Our Ref: EP/158/19/HH
Your Ref:

Development Demolition of existing garage & outbuildings, ground floor alterations to 2No. bay windows & fenestration & external materials alterations, erection of a new balcony, replacement garages & new dormer.

Location The Breakers 29 Tamarisk Way East Preston

1:100 South Elevation

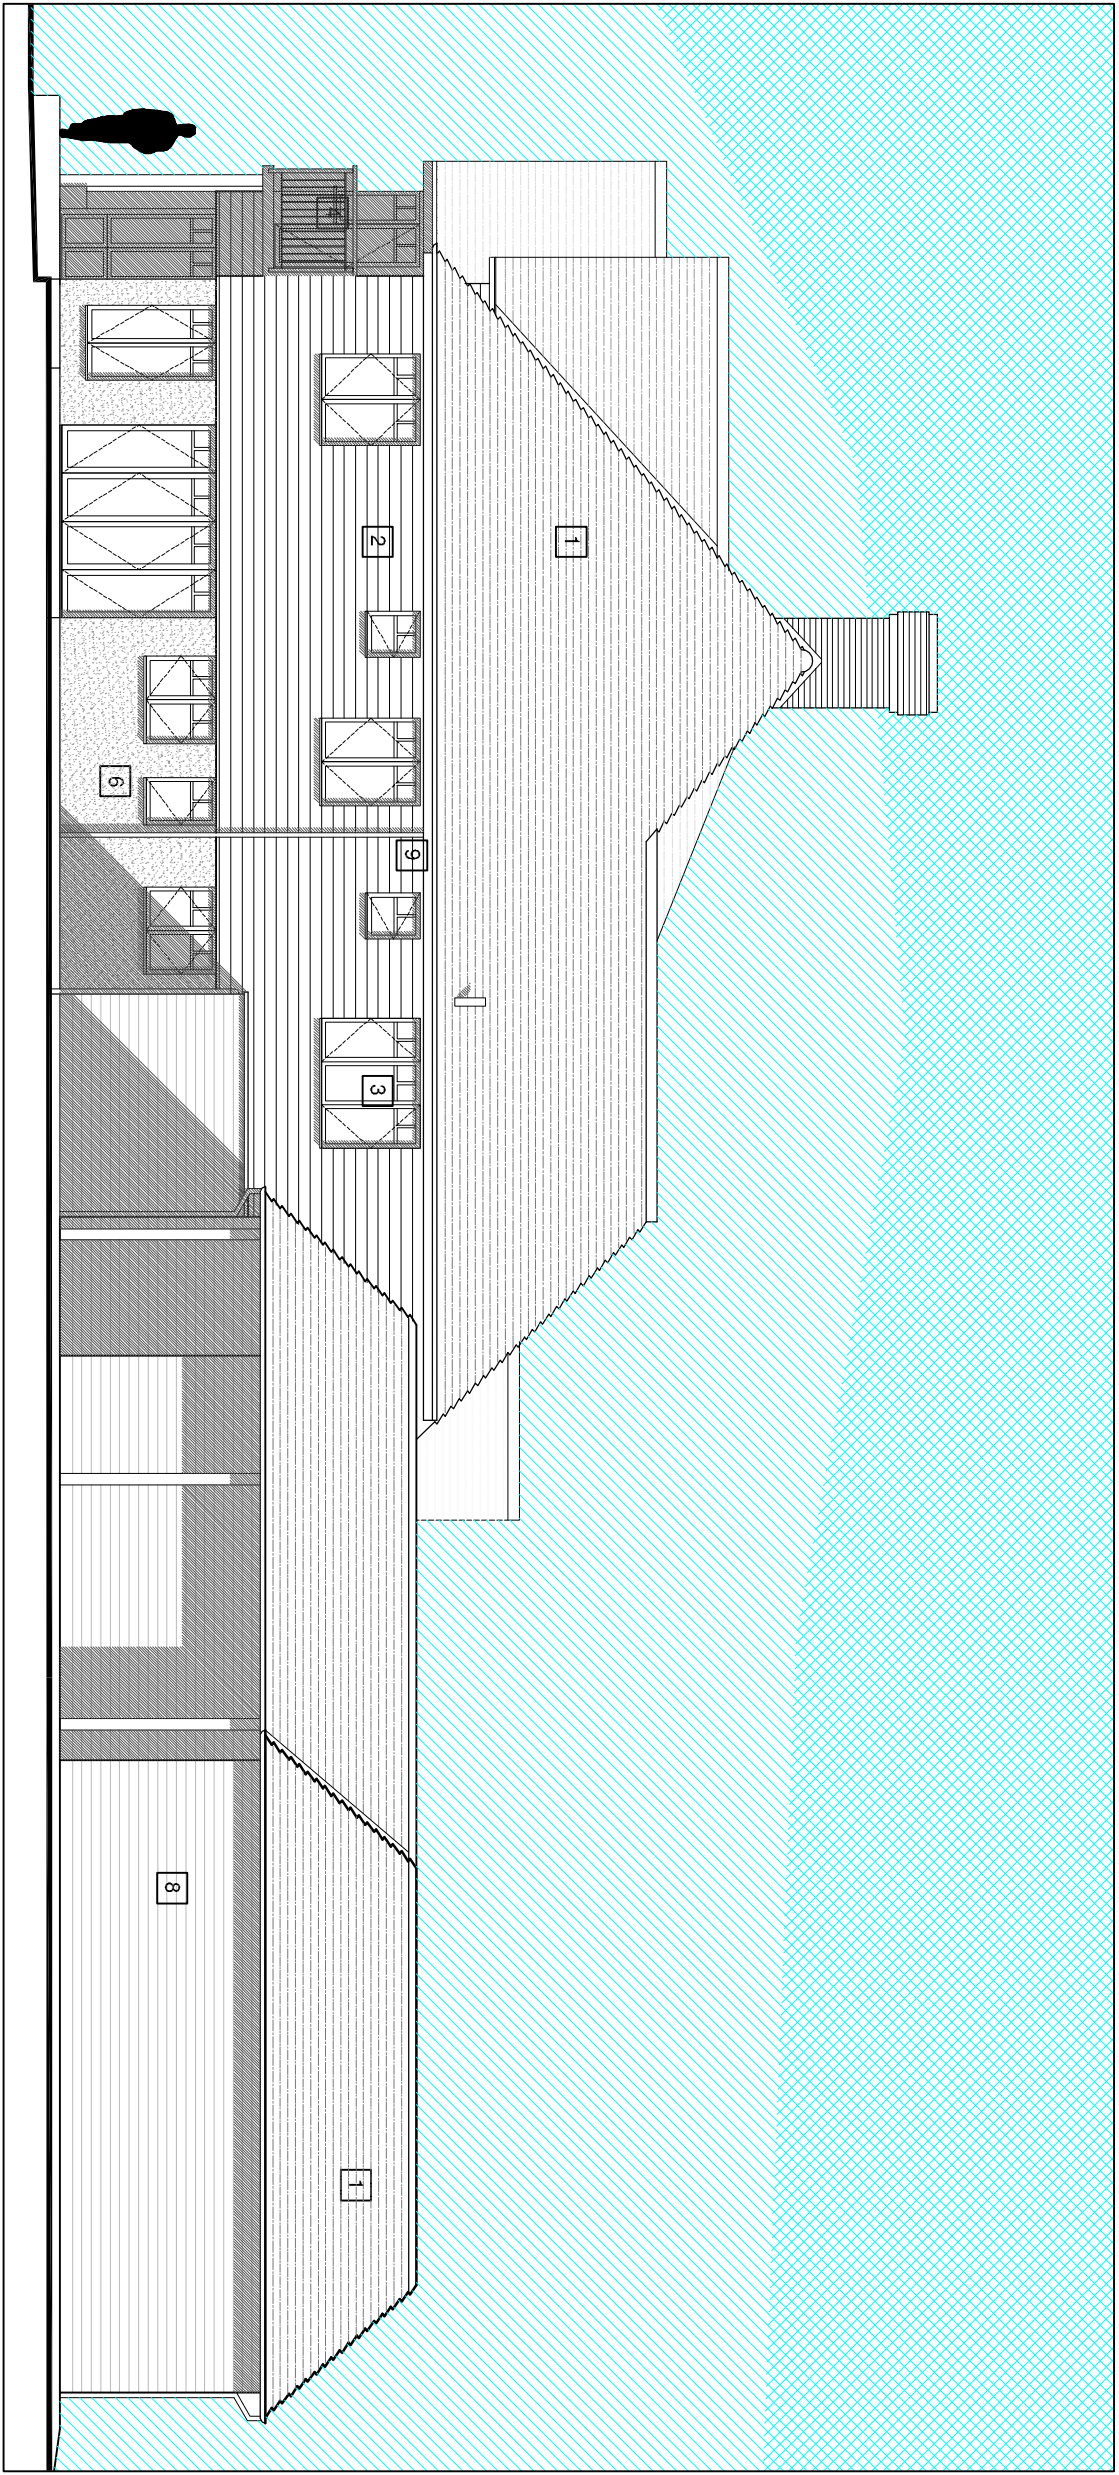
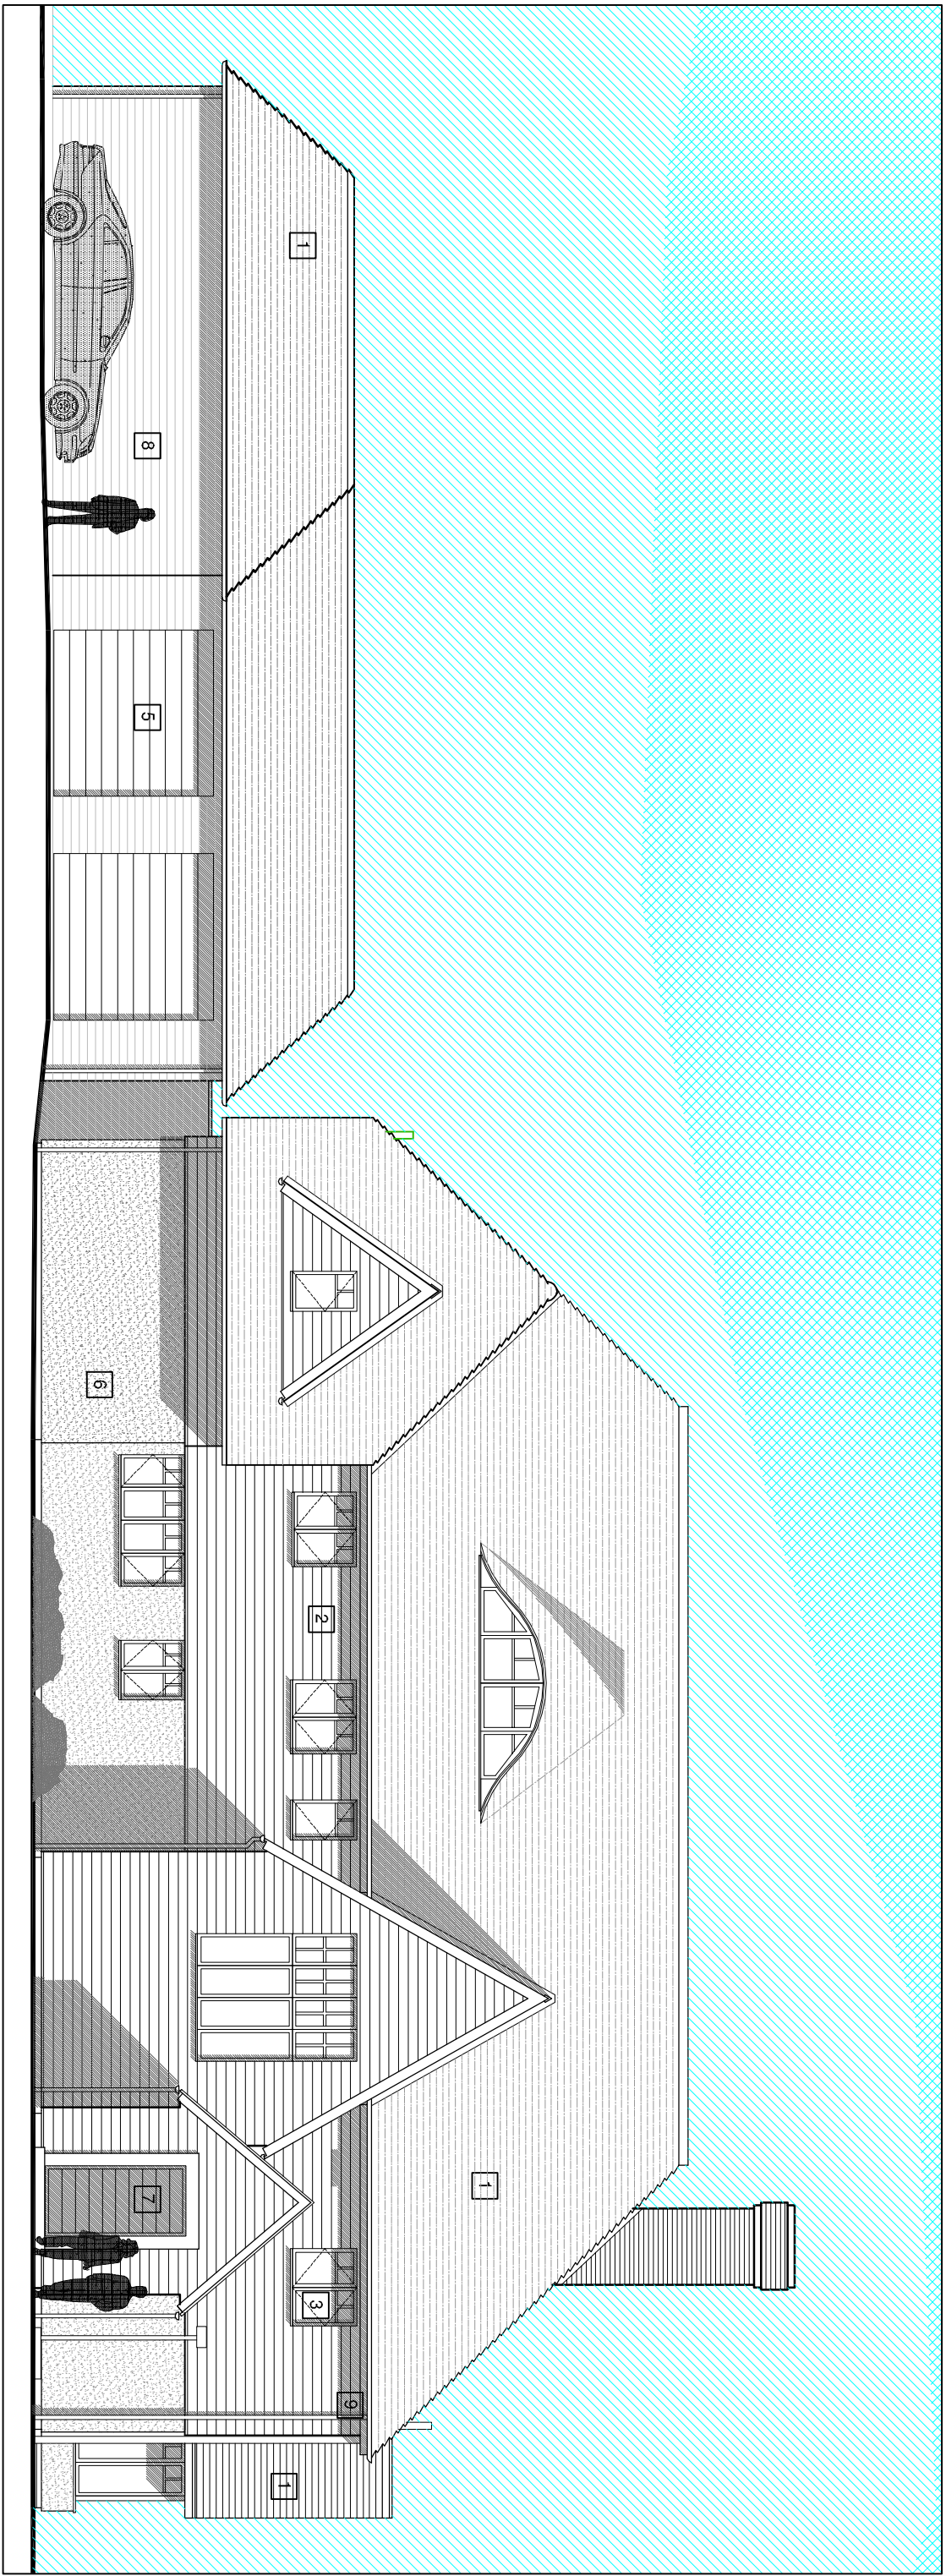
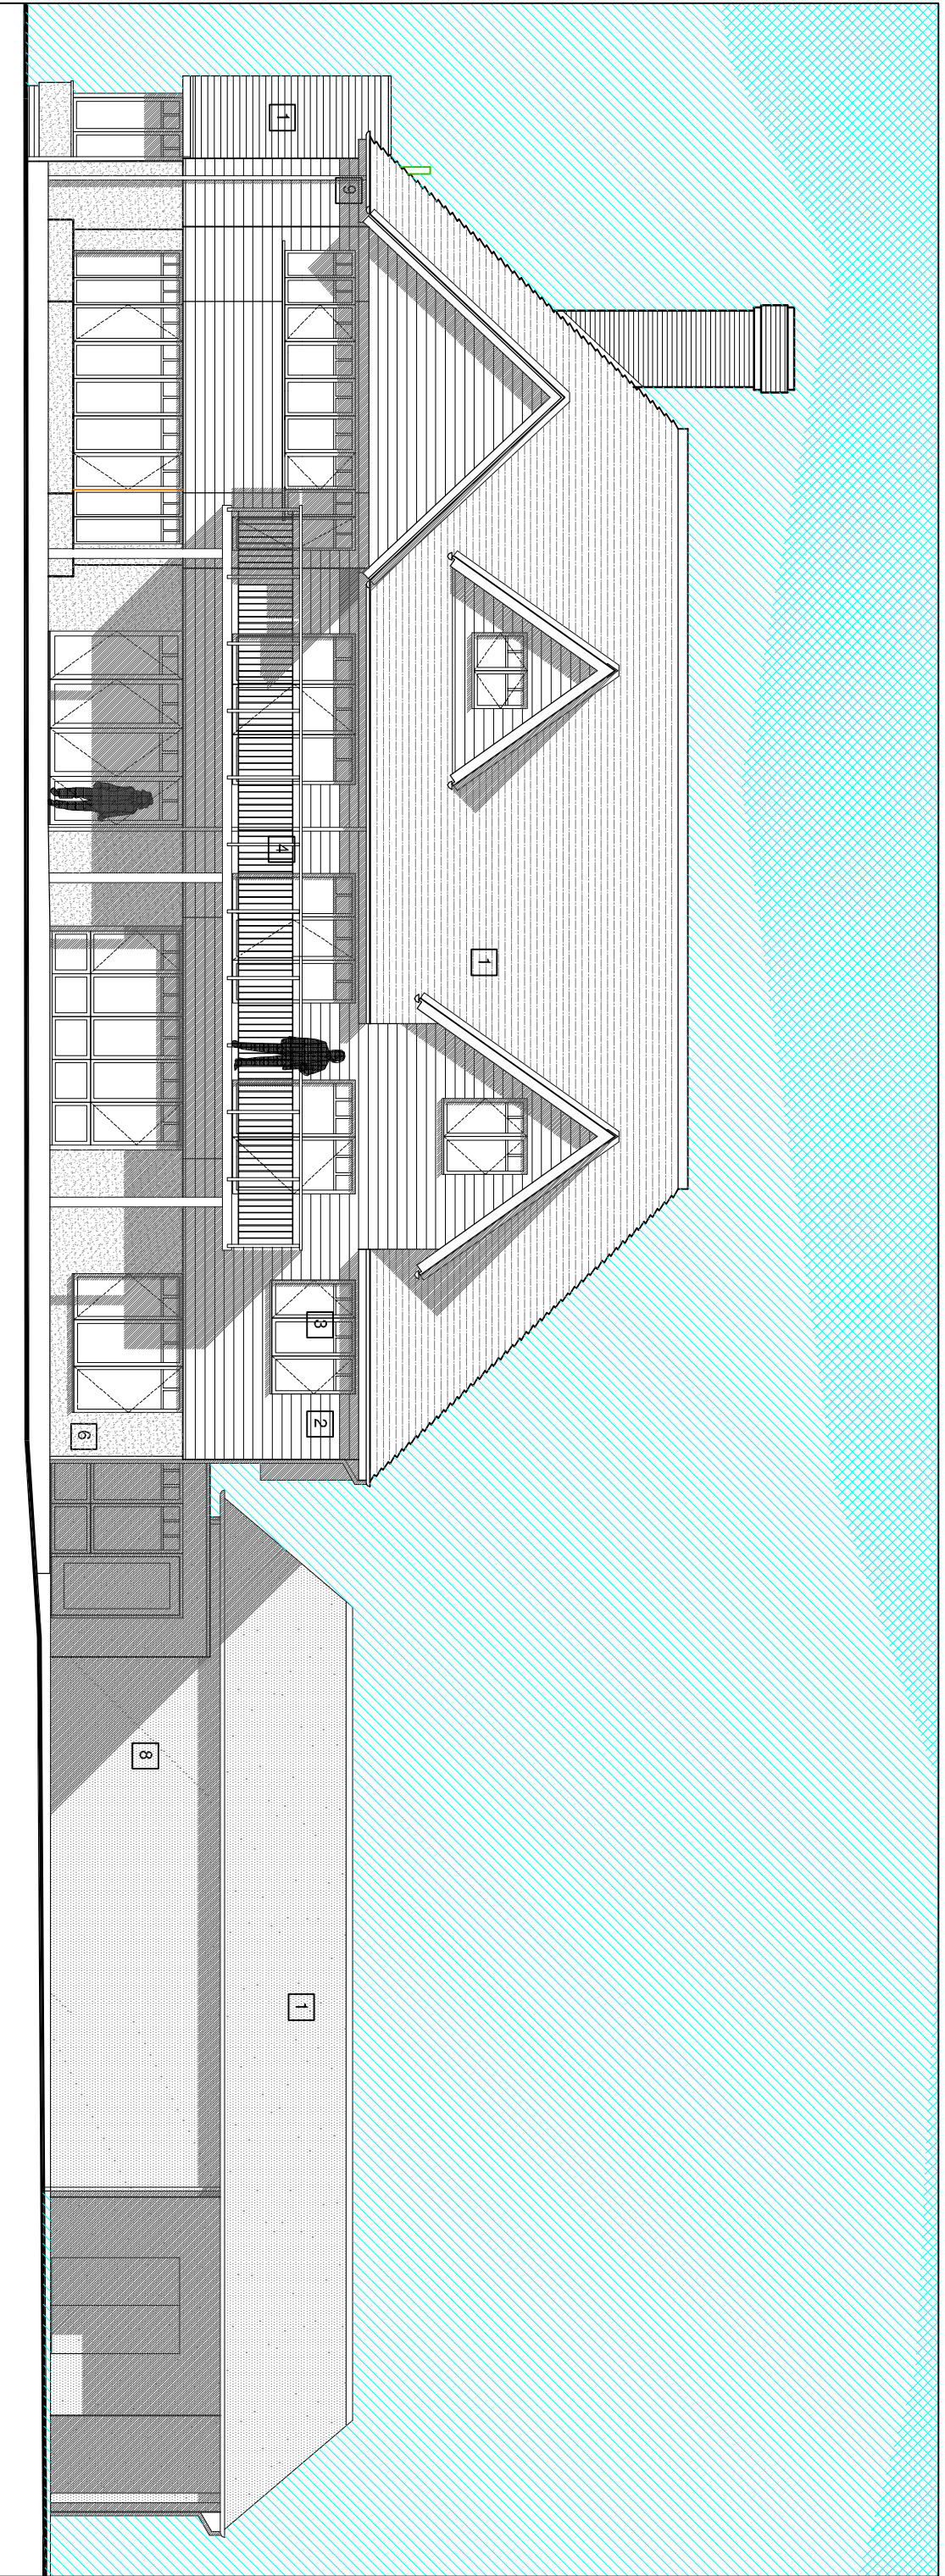
The proposed South elevation and second floor dormer window does not scale correctly. Please amend accordingly
